## City of Albuquerque Stormwater Construction Site Inspection Report

General Information					
ESC File No.	H14E100	Project Name:	Agenda Global Warehouse		
NPDES Id. No.	NMRT0045X	Location:	1715 5th St NW		
6/13/2023	Owner		Contractor		
Operator	Agenda Real Estate Holdings, LLC		T2 Building LLC		
Contact name & title	Chris Taylor - Partner		Harold Stanley		
e-mail	<a href="mailto:ctaylor@agenda-global.com">ctaylor@agenda-global.com</a>		<a href="mailto:hstanley@HDSTAN.com">hstanley@HDSTAN.com</a>		
Contact Phone #	505-450-4703		803-8582		
COA Inspector	Chancellor English		Start/End Time:	3pm	
Construction Phase:	Construction				
Type of Inspection:	Regular	Storm Event	Post Storm Event >0.25"	311/Complaint	Follow Up
Weather at time of inspection?	Clear		Temperature: ~	80	
Estimated date of last storm 0.25" or greater	5/22/2023

ESC-1

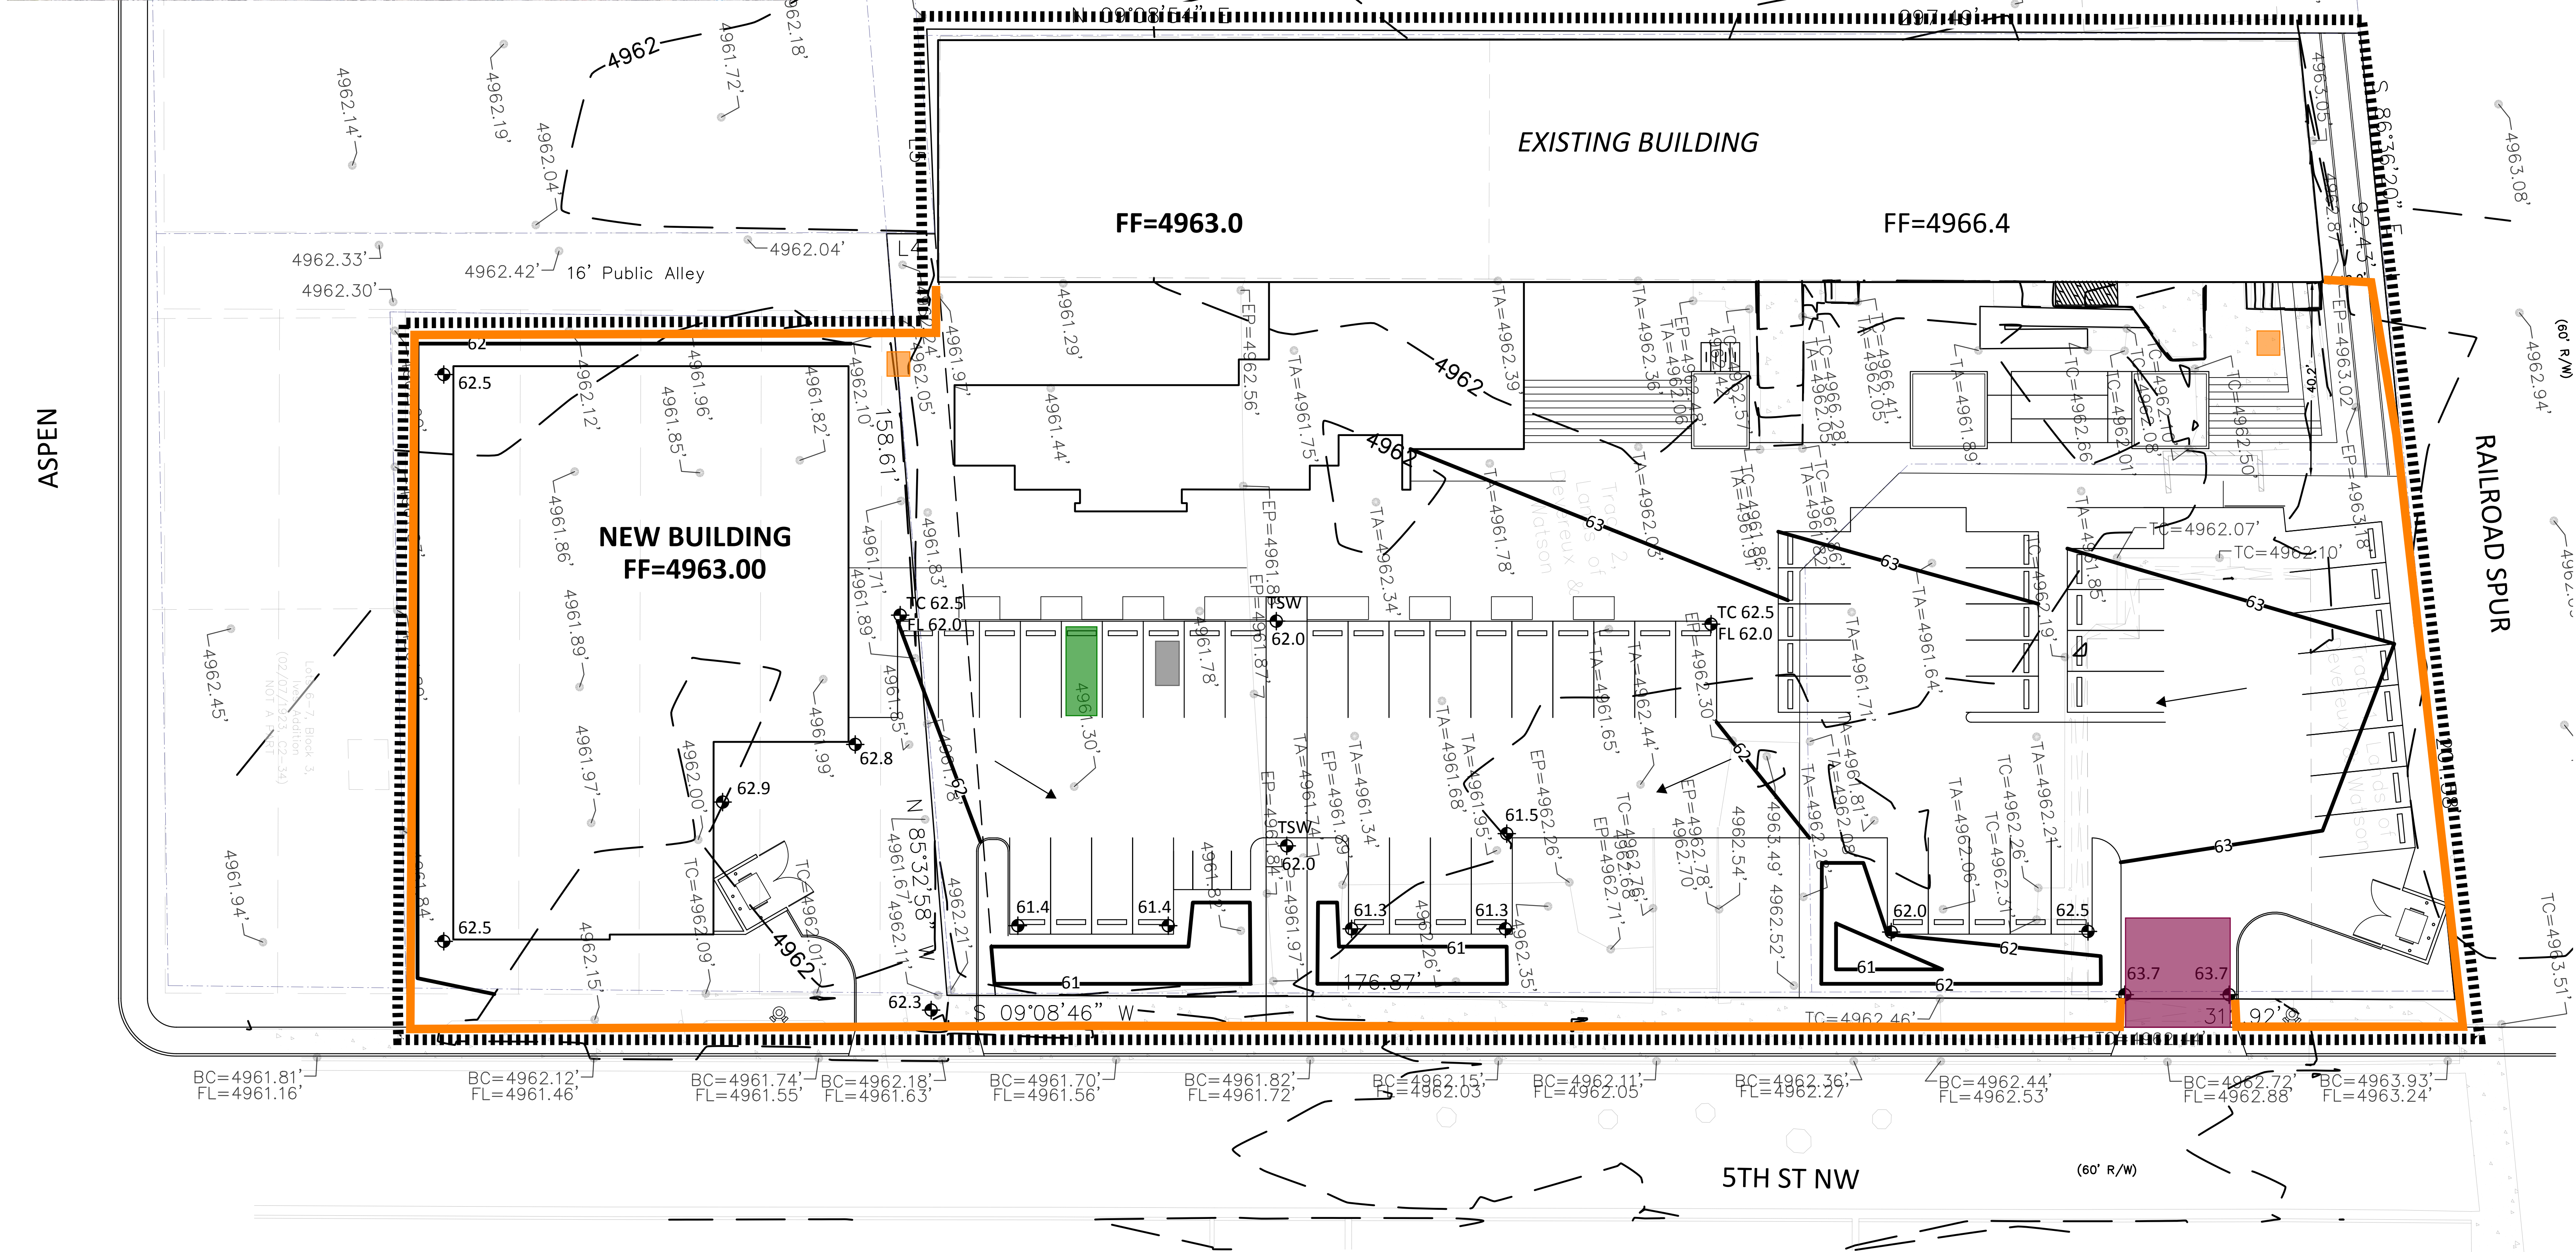
Item Number	Deficiency/ Corrective Action				
1	There were no BMPs installed at time of inspection. The ESC Plan shows a silt fence surrounding the perimeter. The CGP Section 2.1.4 states that you must ensure all stormwater controls are maintained and remain in effective operating condition during permit coverage.				
2	Washout was noted in several areas of the site, but no lined washout container. According to Section 2.3.4 of the CGP, you must direct wash water into a leak-proof container or leak-proof and lined pit; do not allow liquid wastes to be disposed of through infiltration or on the ground.				
3	The dumpster was not covered at the end of the work-day - contractors left during inspection. As per CGP Section 2.3.3.e, provide waste containers of sufficient size and number, and, for those without lids, provide a cover or similarly effective means designed to minimize the discharge of pollutants.
